**ADC Planning Consultation
Response from the Conservation Officer**

Application Number	AL/63/14/HH
Address	Crunchy Cottage Park Lane Aldingbourne PO20 3TJ
Description	Demolition of existing summerhouse, stables & 2 No extensions & new rear extension & new detached garage/storage building to converted residential barn.
Case Officer	Mr. S. Davis

Drawing: Proposed NW & SE elevations (1:100@A3)

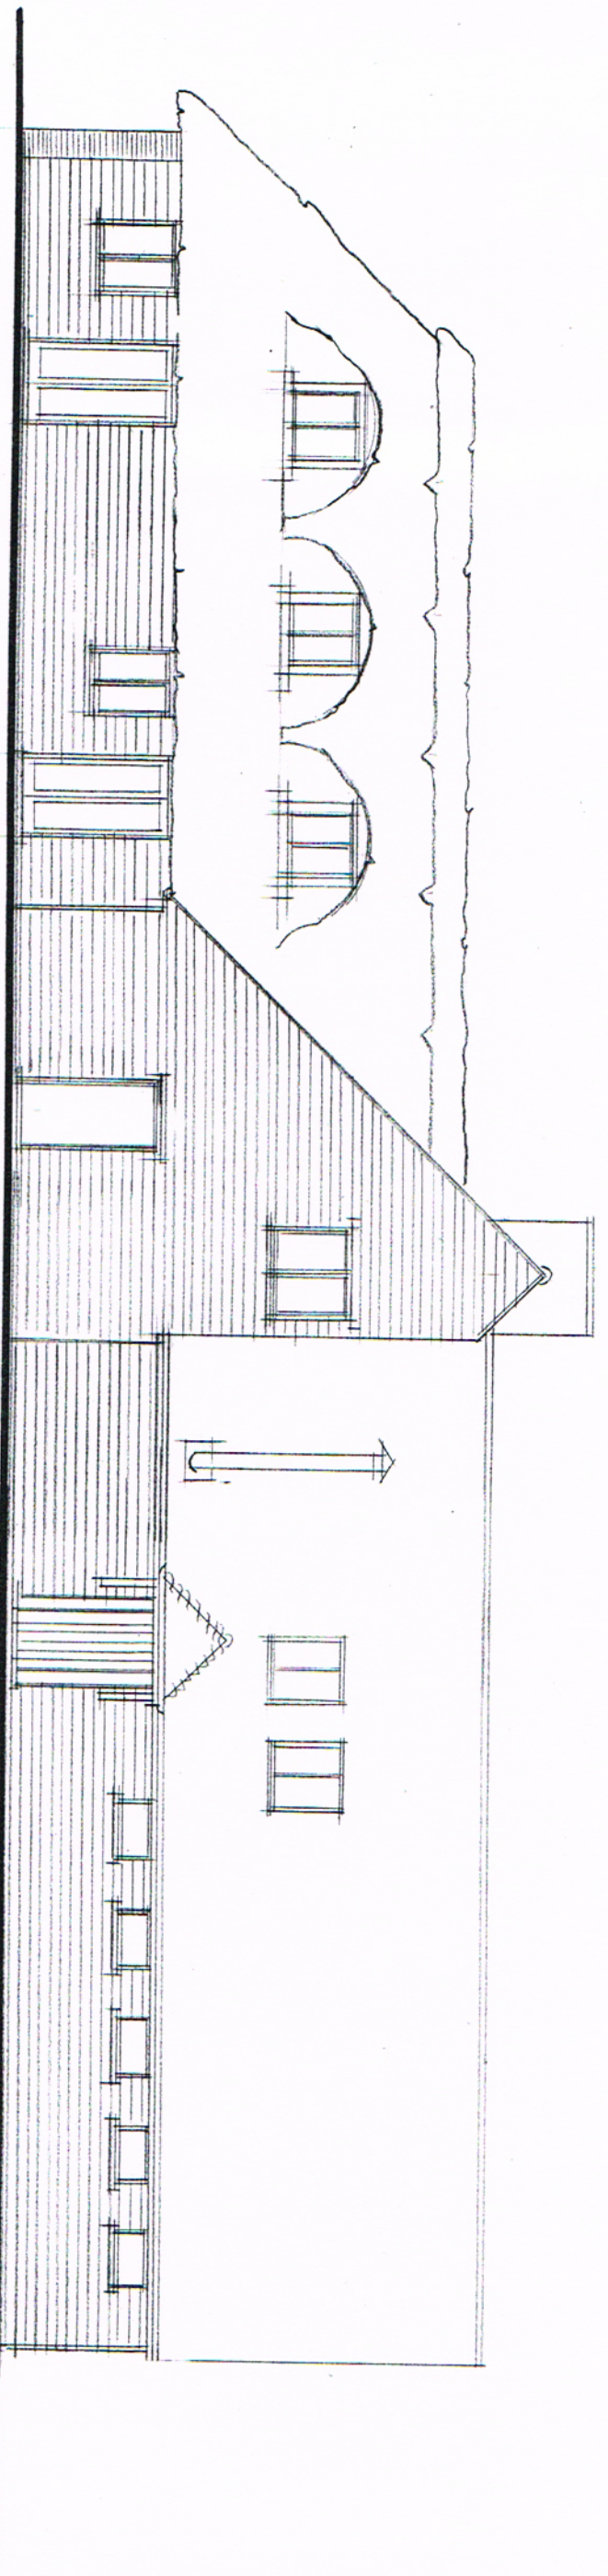
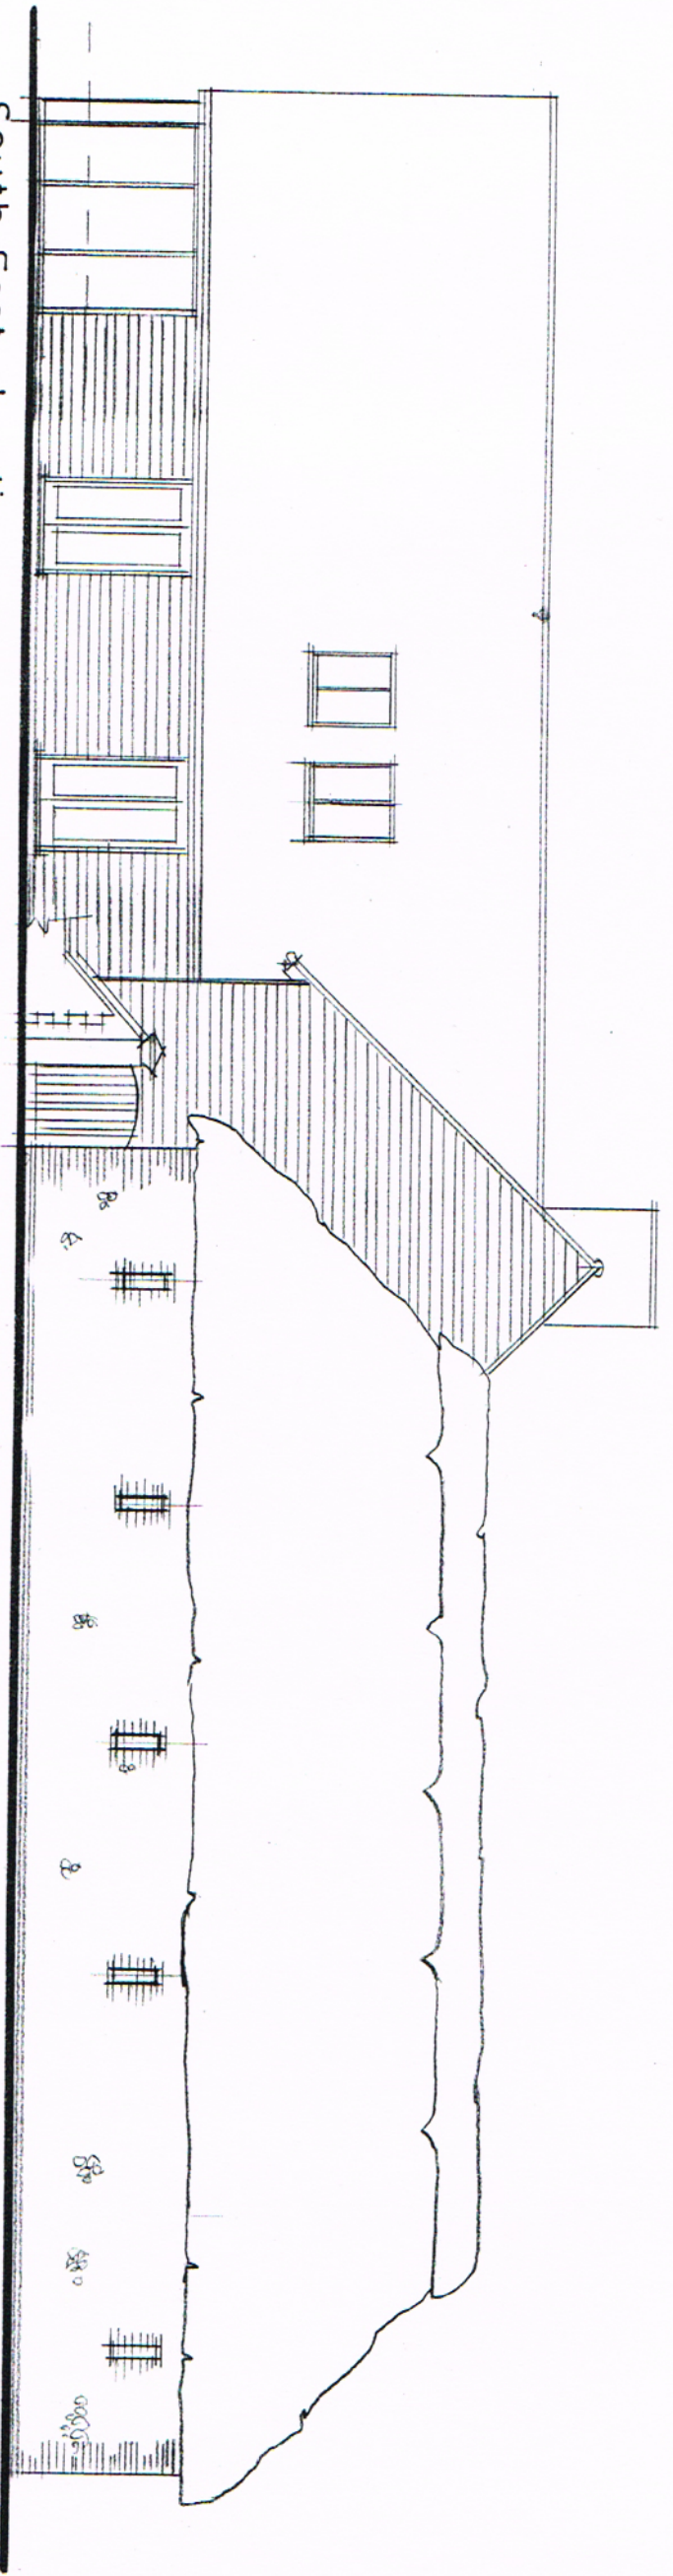
The proposed replacement 'extension' is substantial and cannot be considered as subservient. It appears as if the intention is to create a 'barn complex', as opposed to one independent unit.

The design of the 'extension' contrasts with the existing structure and attempts to reflect the neighbouring property, Tithe Barn.

It is noted that information such as the proposed street-scene appears to be based on the use of 'mature' trees/planting. Is this the case? It is considered that semi-mature vegetation should be used to reduce the impact of the scheme and 'bed' it into its rural location.

Drawing: Proposed garage building (1:100@A3)

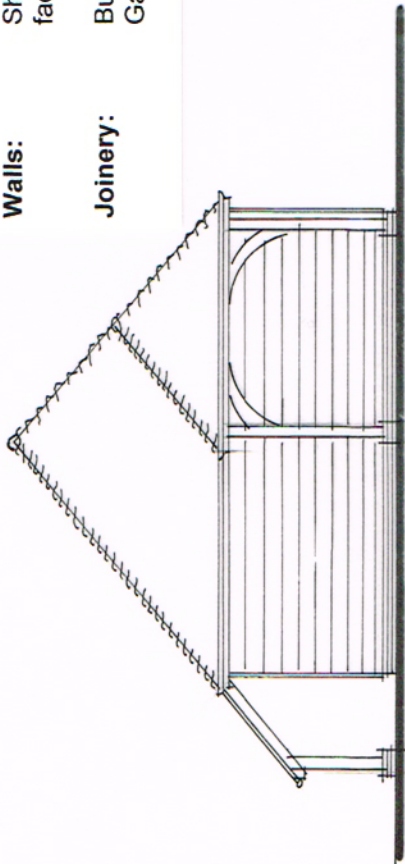
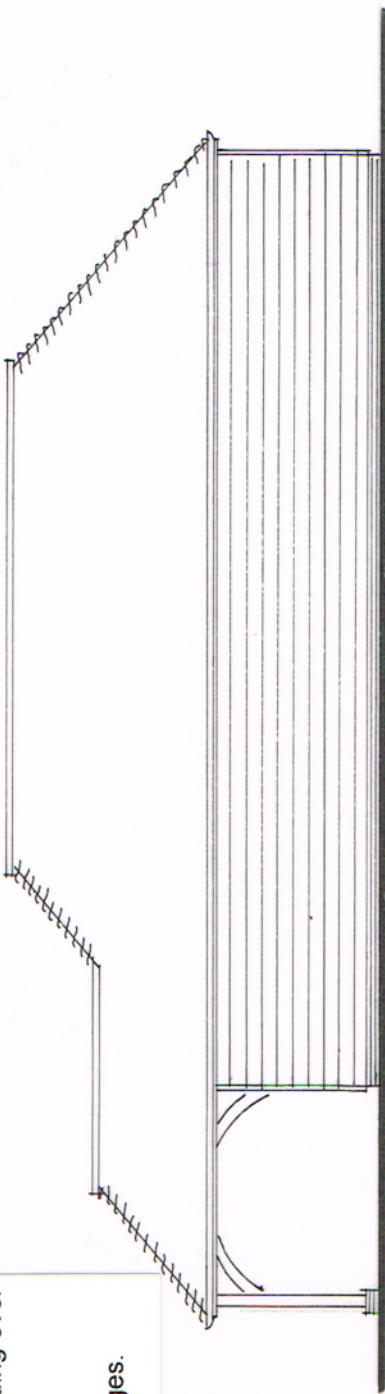
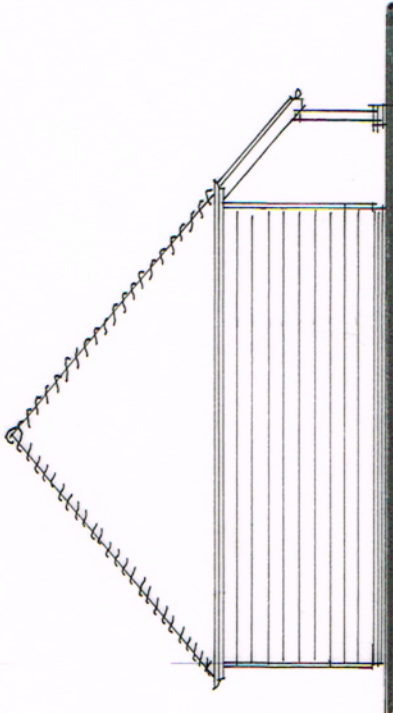
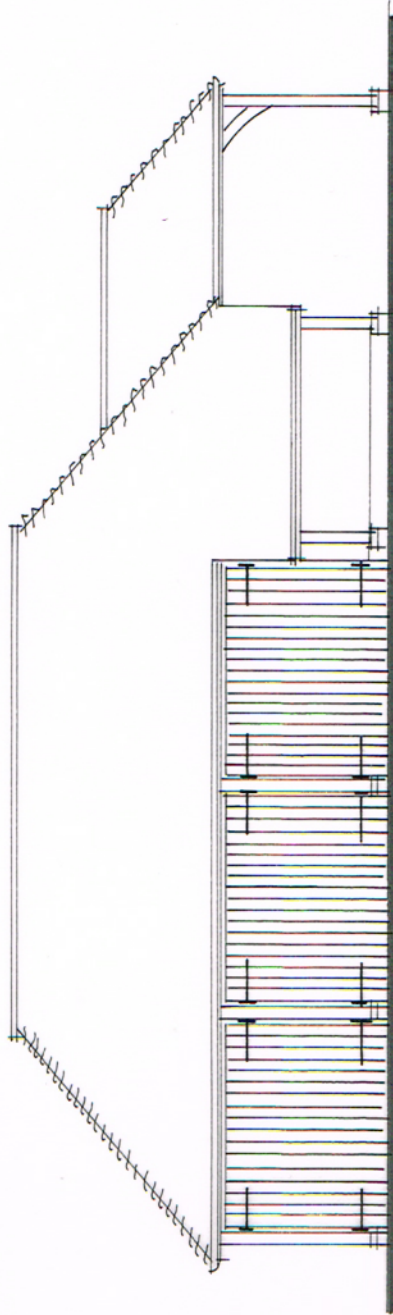
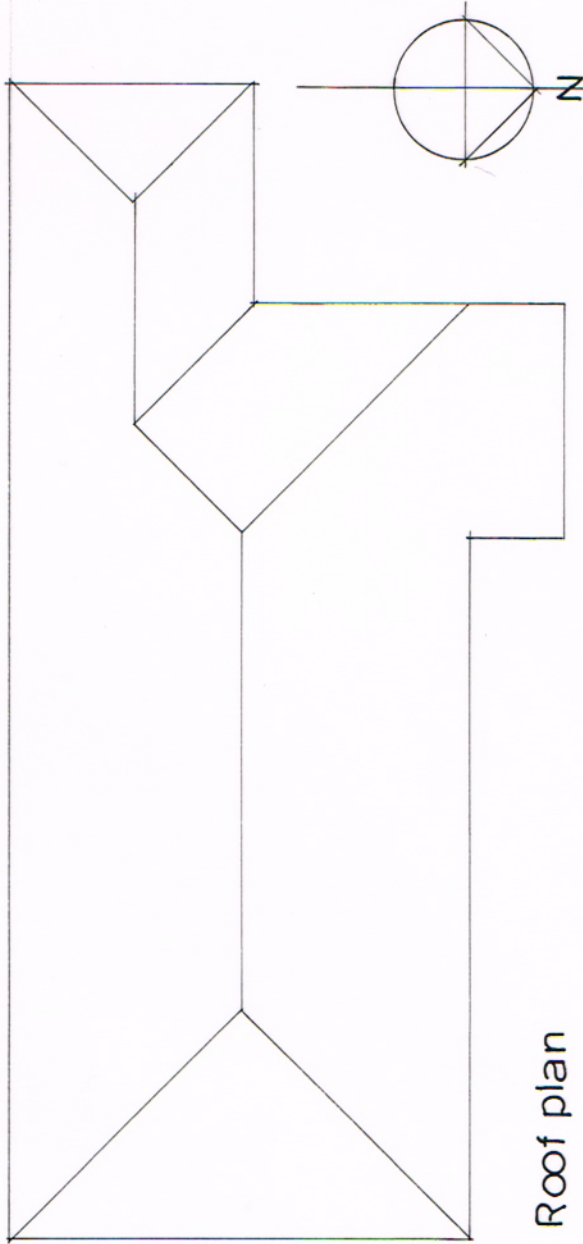
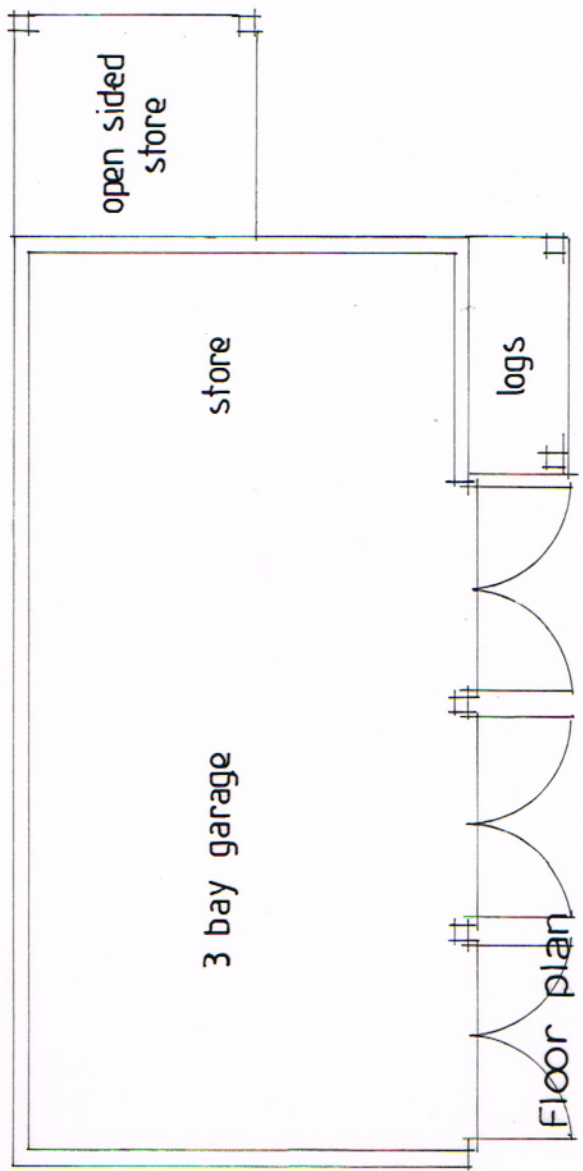
The proposed garage is a substantial structure, with the potential to impact upon the street-scene and the neighbouring property. Success of such an element will depend upon the use/treatment of the cladding materials to reflect those found in the locality.

DRAWING LANDSCAPE PLAN

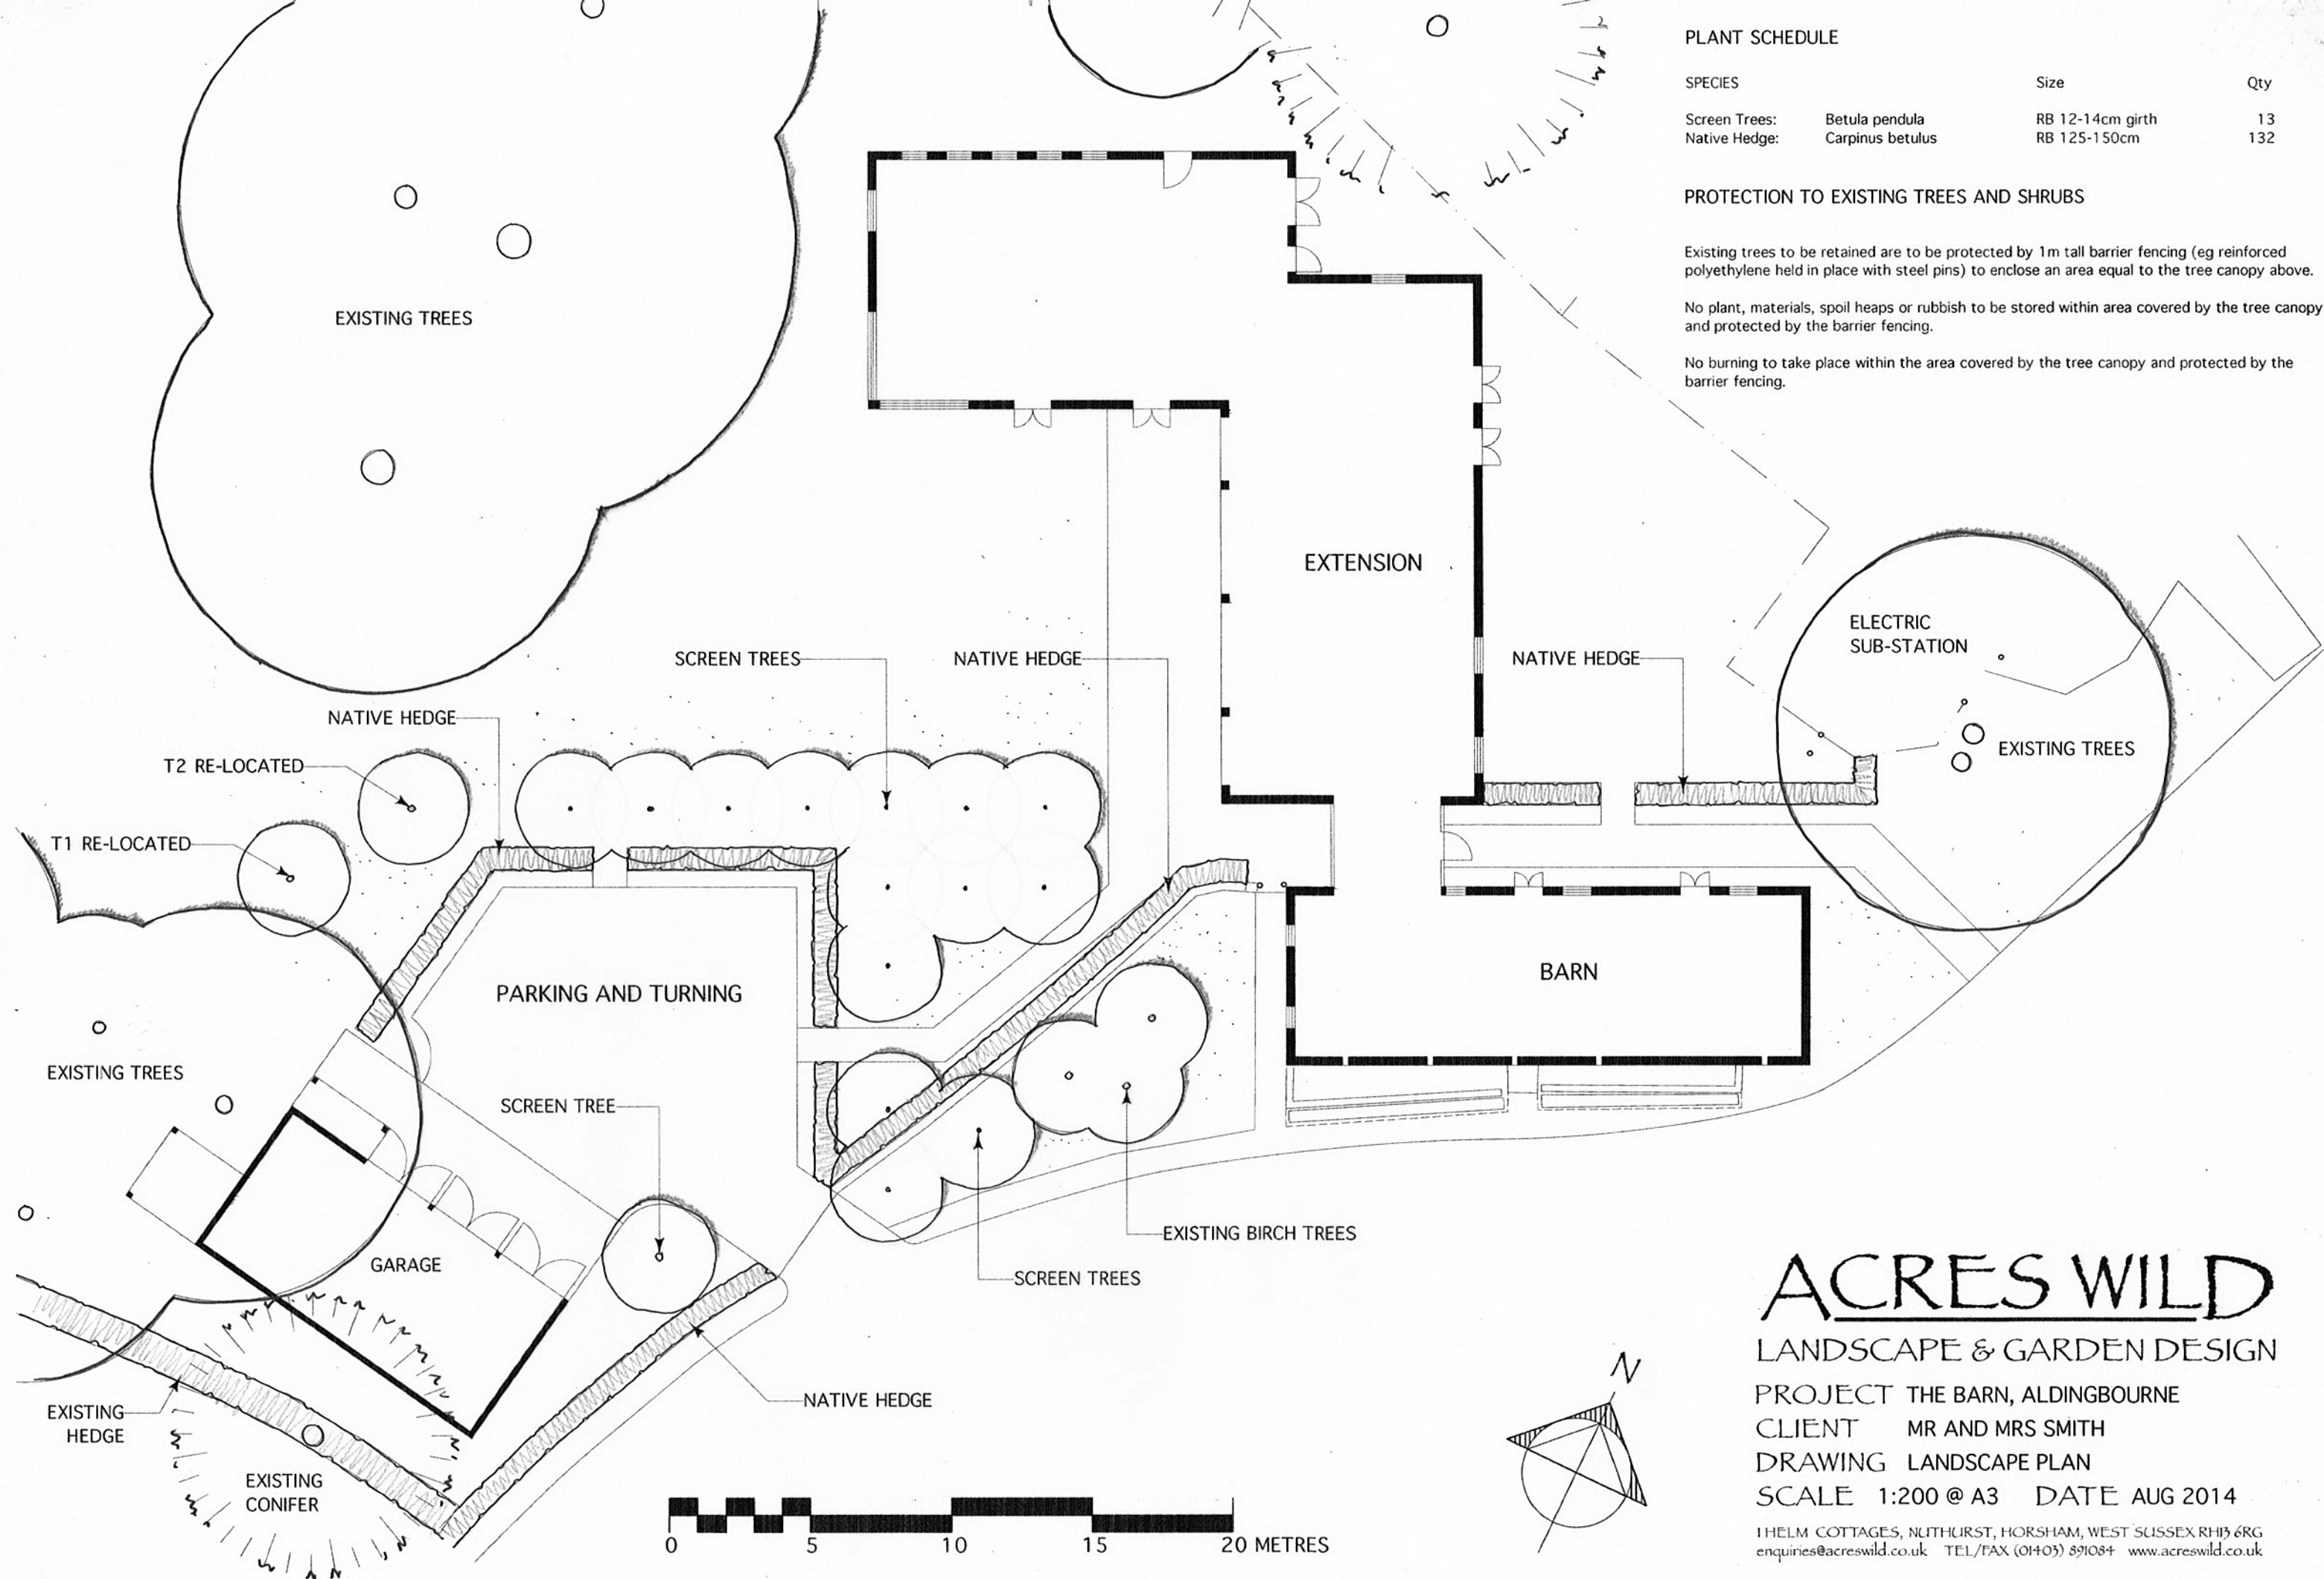
If minded to approve this proposal, it is considered that materials and joinery should be conditioned. It may also be beneficial to request further details regarding landscaping for our green-space to provide assistance on.
